From: Liz Annalls [REDACTED]
Sent: 27 January 2022 12:19
To: Planning.Responses <Planning.Responses@arun.gov.uk>
Subject: RE: Planning Consultation on: WA/5/22/PL

App No: WA/5/22/PL
Address: Morelands Arundel Road Fontwell BN18 0SB
Proposal: Demolition of 1 No dwelling & erection of 5 No dwellings with associated car parking and access. This site is in CIL Zone 2 and is CIL Liable as new dwellings.

TITLE
**Building B -
Elevations**

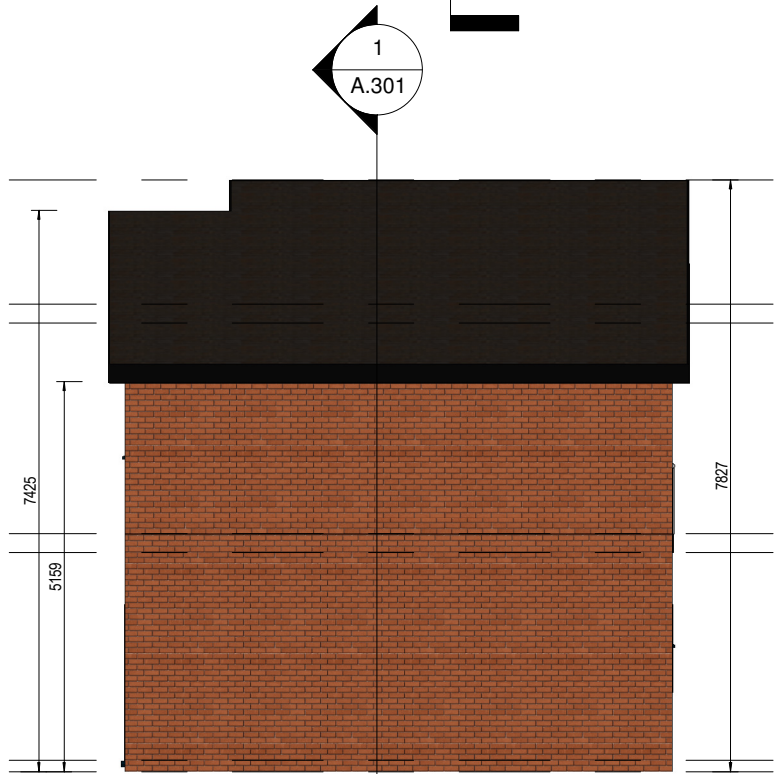
We require that a bat brick is integrated into the buildings onsite facing south/south westerly positioned 3-5m above ground
